City of Portland, Maine - Building or Use Permit Application

Location of Construction: 177 Clinton St	Owner Name: Pizzo Nancy J	Owner Address: 177 Clinton St	Phone: 207-773-5787
Business Name: n/a	Contractor Name: D.L. George & Son	Contractor Address: 45 Moody Road Limington	Phone: 2077938102
Lessee/Buyer's Name n/a	Phone: n/a	Permit Type: Amendment to Single Family	Zone: R-5

Past Use: Single Family	Proposed Use: Single Family / Amendment to Permit # 011356; added Match window to other window.	Permit Fee:	Cost of Work: \$0.00	CEO District: 3
		FIRE DEPT: <input type="checkbox"/> Approved <input type="checkbox"/> Denied <i>N/A</i>	INSPECTION: Use Group: <i>R-3</i> Type: <i>SB</i> <i>BOCA 1979</i>

Proposed Project Description: Amendment to permit # 011356 to add Match window.	Signature:	Signature:
	PEDESTRIAN ACTIVITIES DISTRICT (P.A.D.)	
	Action: <input type="checkbox"/> Approved <input type="checkbox"/> Approved w/Conditions <input type="checkbox"/> Denied	
	Signature:	Date:

FOUNDATION PLAN - VENTILATION?

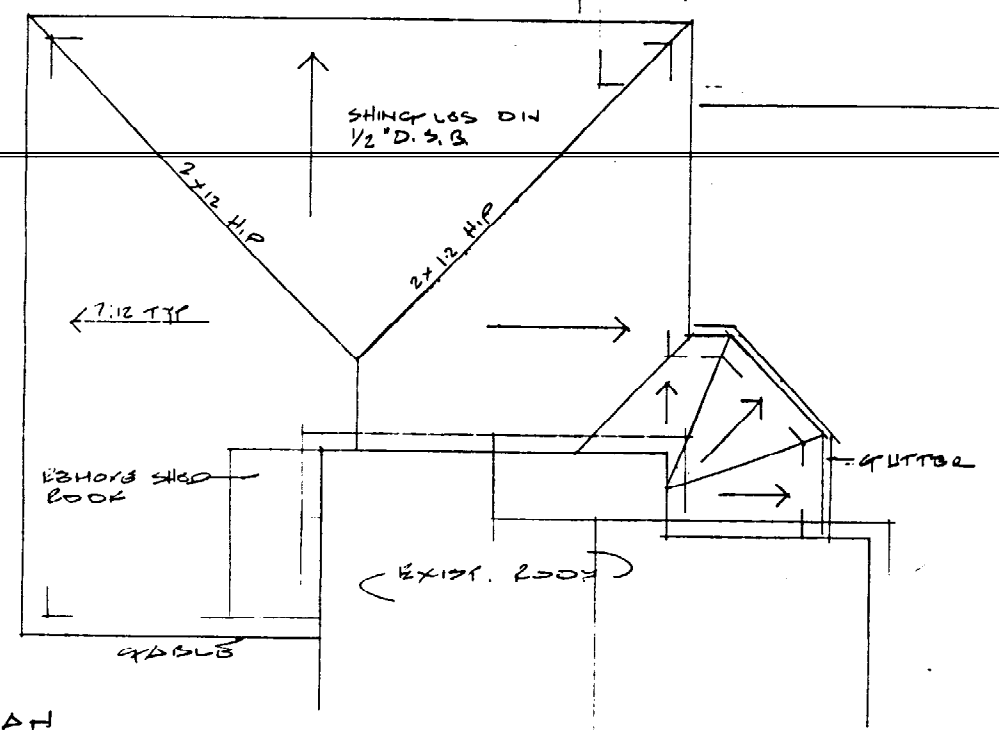
FOUNDATION PLAN - VENTILATION?

FLOOR PLAN

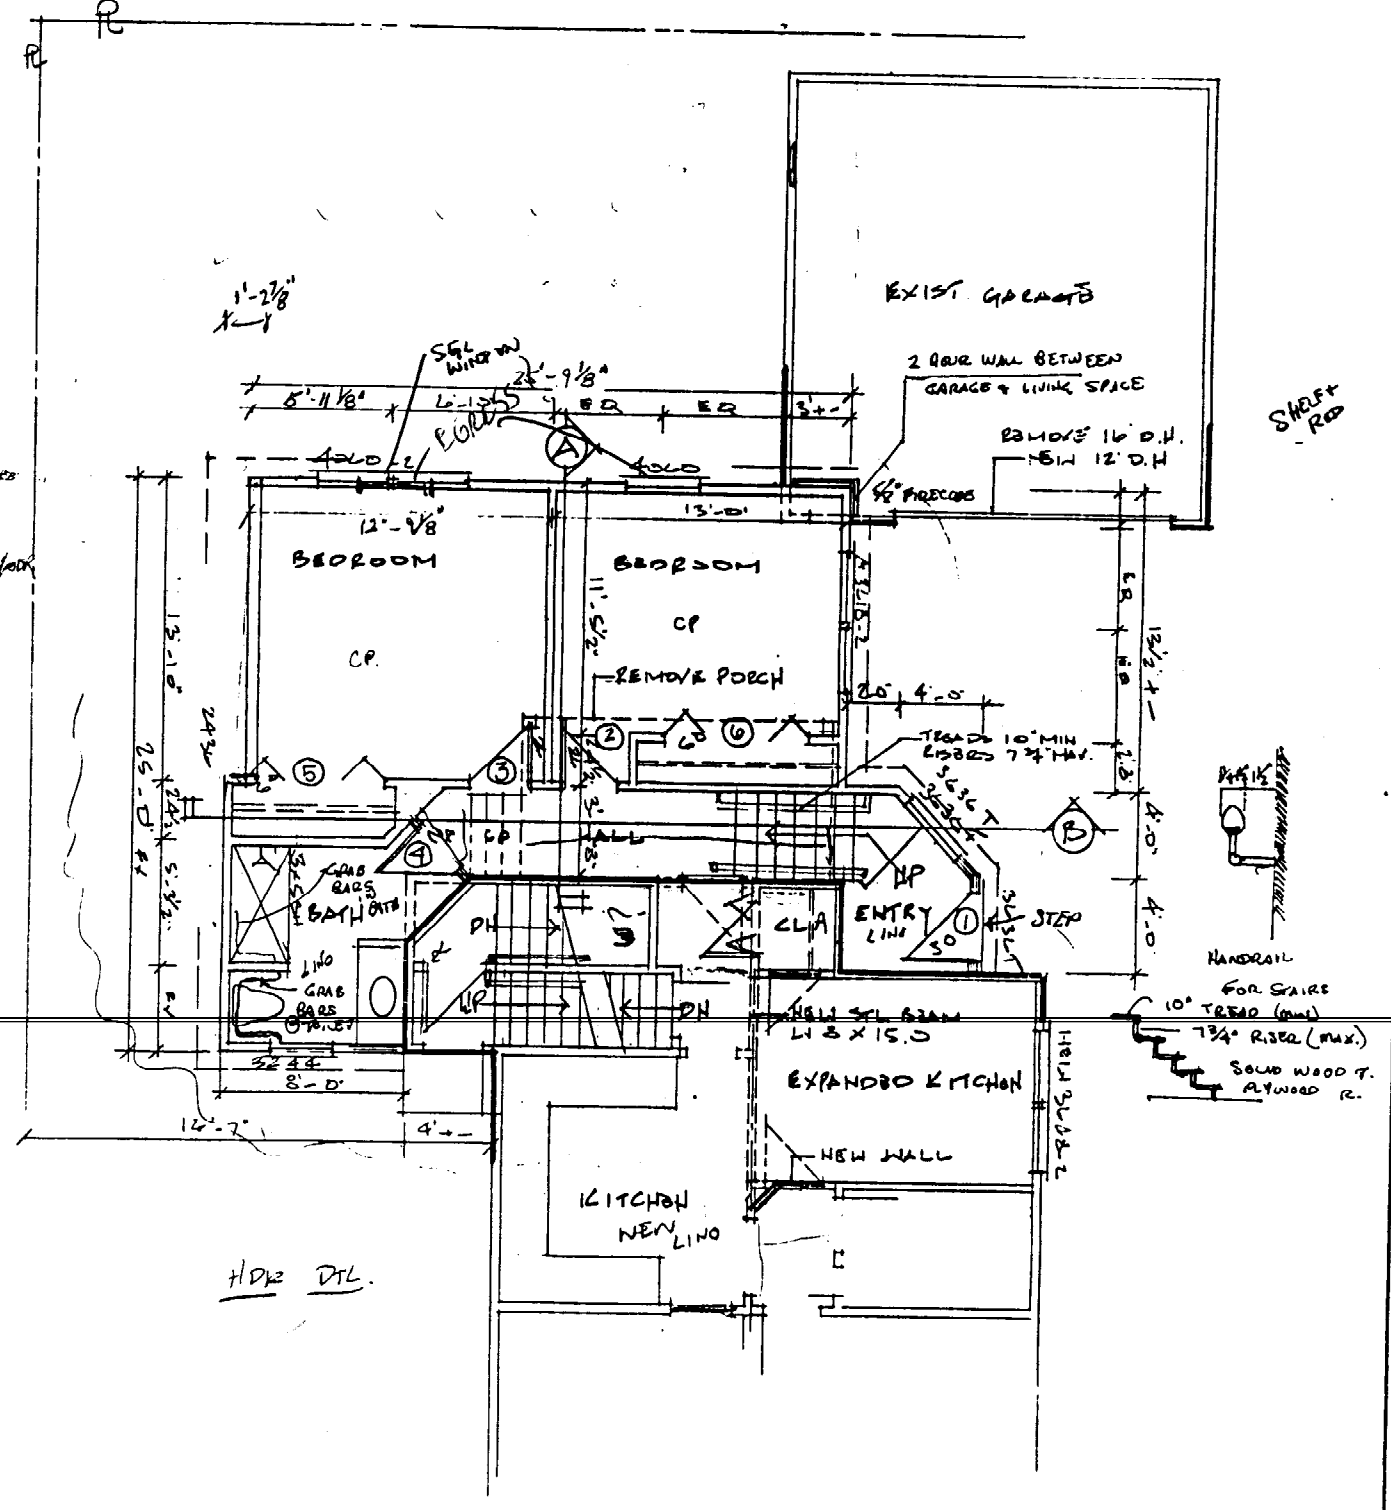
Headers
shown as 2-2x8
typical on other plan

CHANGE TO 2x8
